14 December 2021

Pamela Morales  
Department of Planning, Industry and Environment  
4PSQ Level 17, 12 Darcy Street  
PARRAMATTA NSW 2150

**First Building Bradfield City Centre (SSD-25452459)  
Development Application Submission**

STORMWATER DRAINAGE PLAN

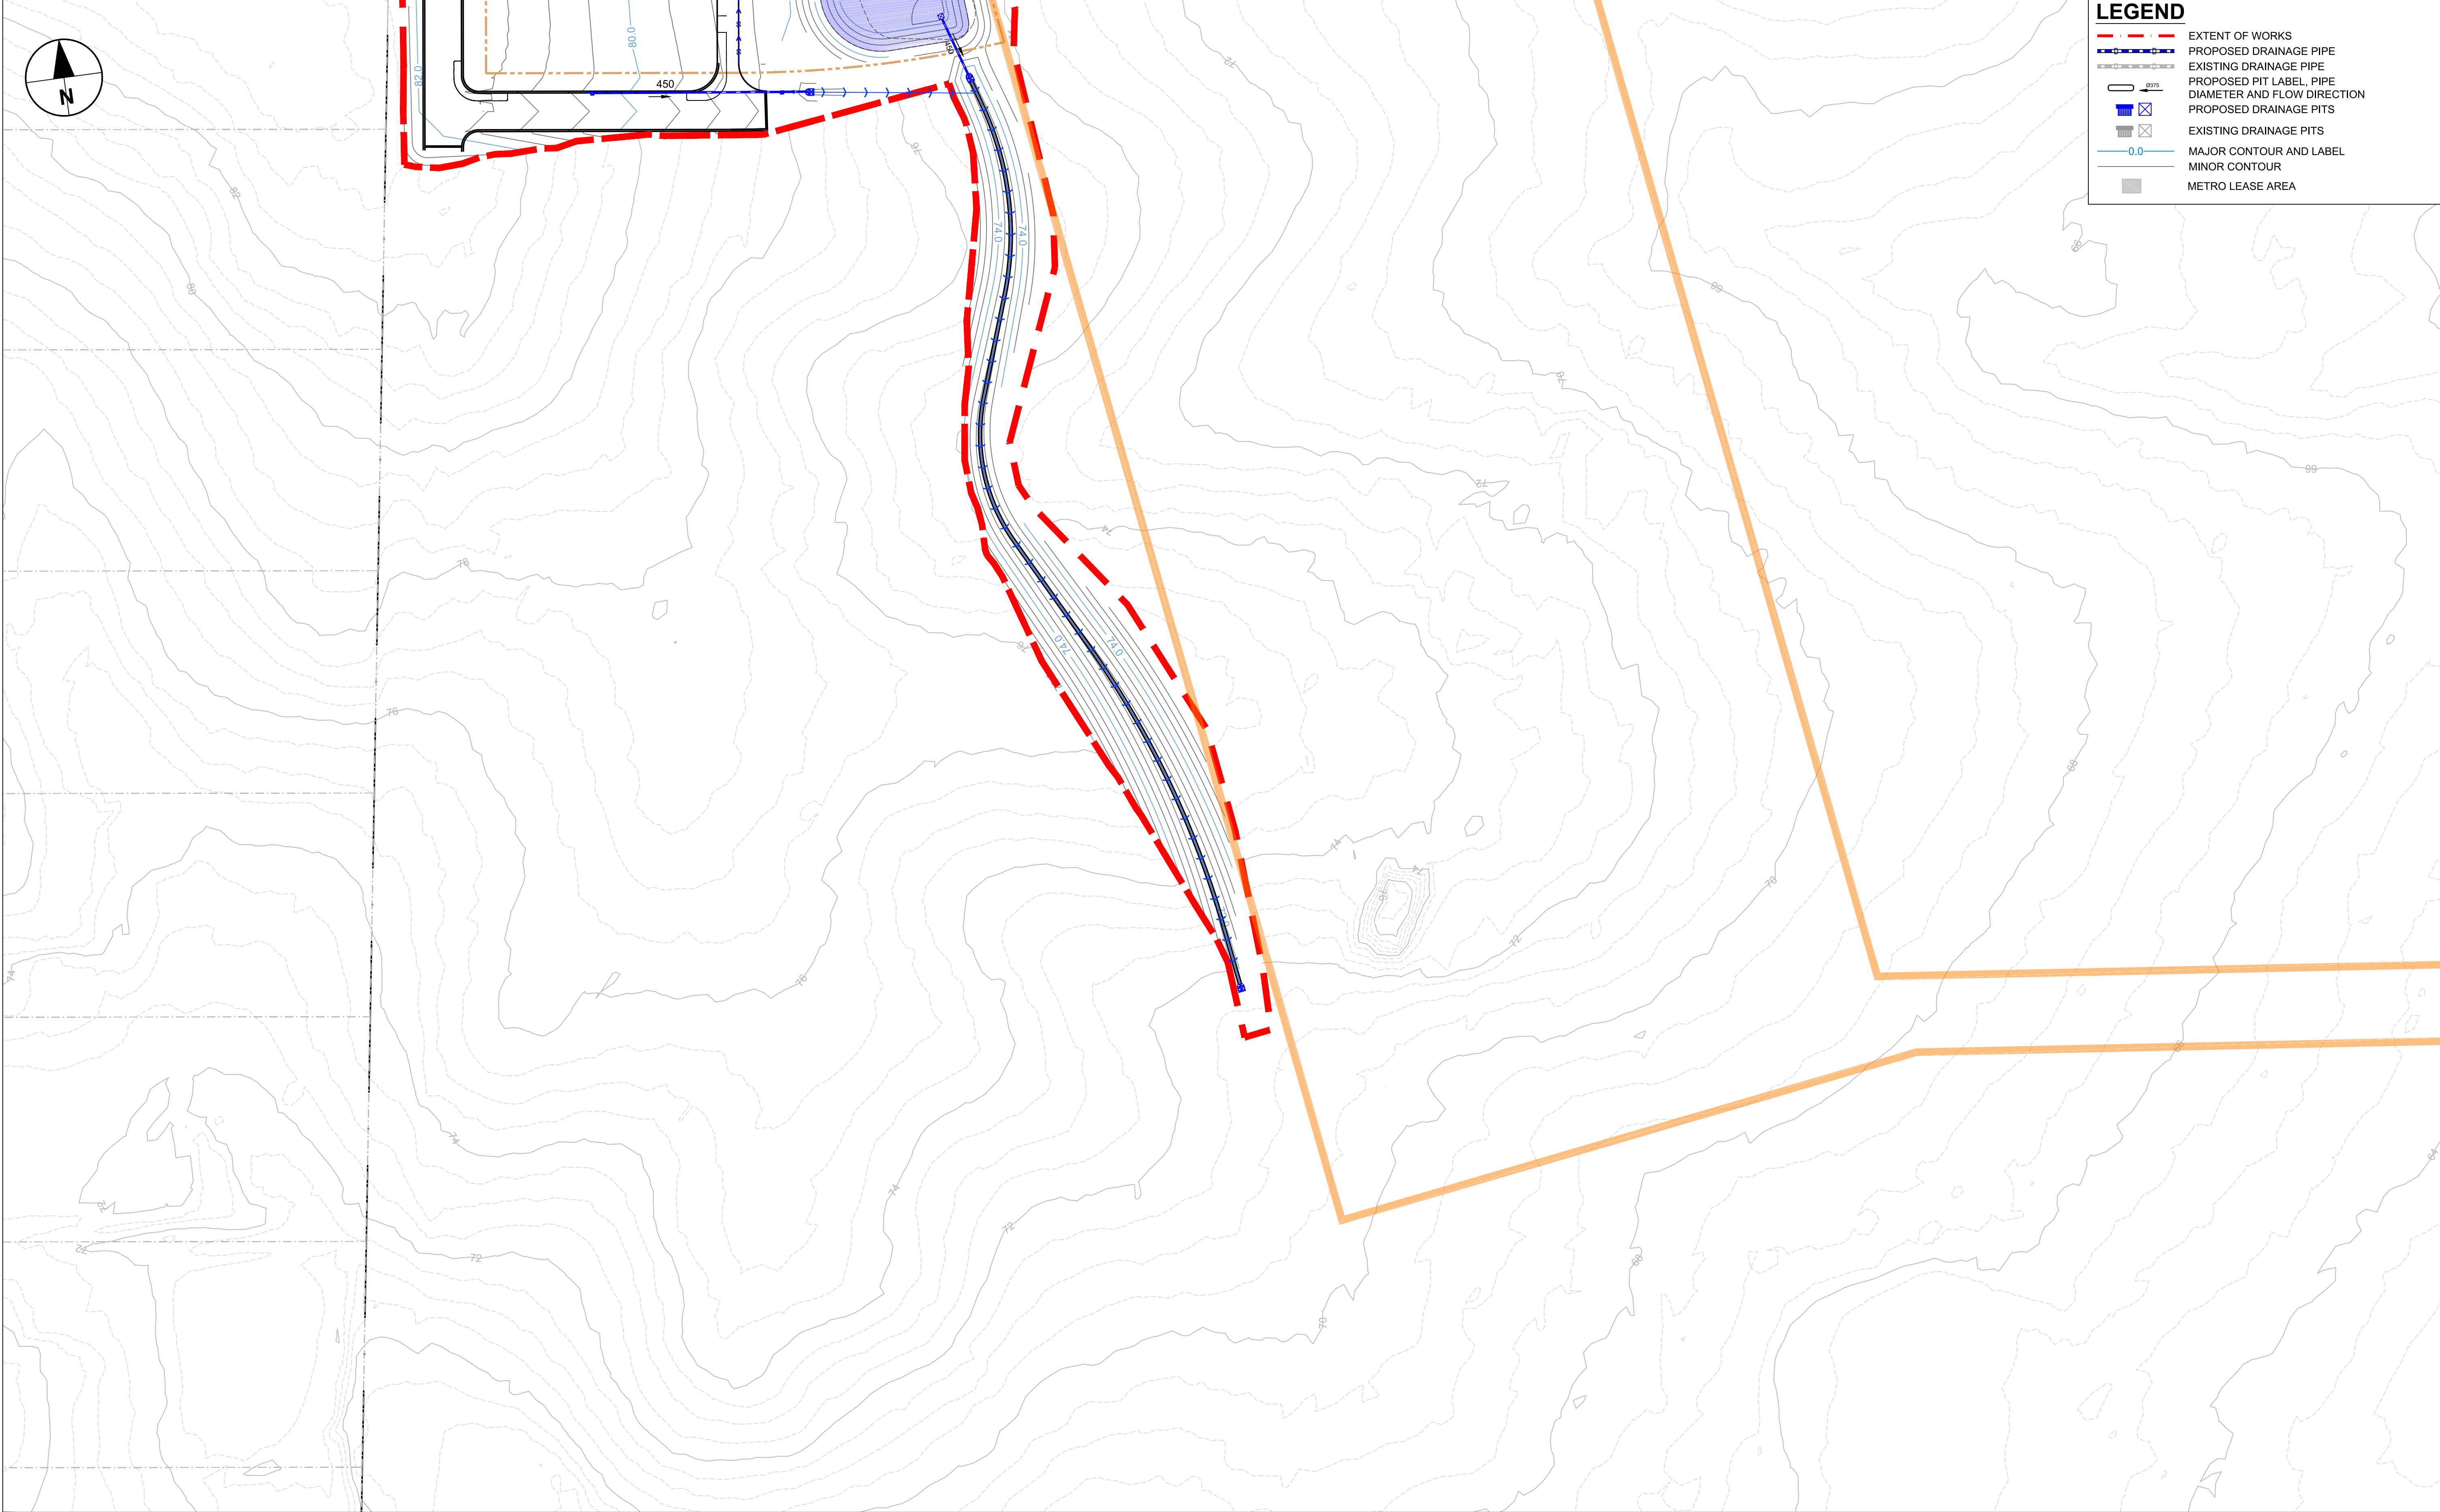
4. From the application, it is understood that drainage is proposed via two temporary basins prior to release via a vegetated and stabilised swale (Section 8.7 Soil and Water). Further detail is requested in relation to the timeframes for the construction and operation of these basins, noting that in the longer term it is considered that permanent basins / WSUD measures would be proposed.

**Recommendation:** That further detail be provided in relation to the length of time that the proposed temporary basins would be constructed and operated.
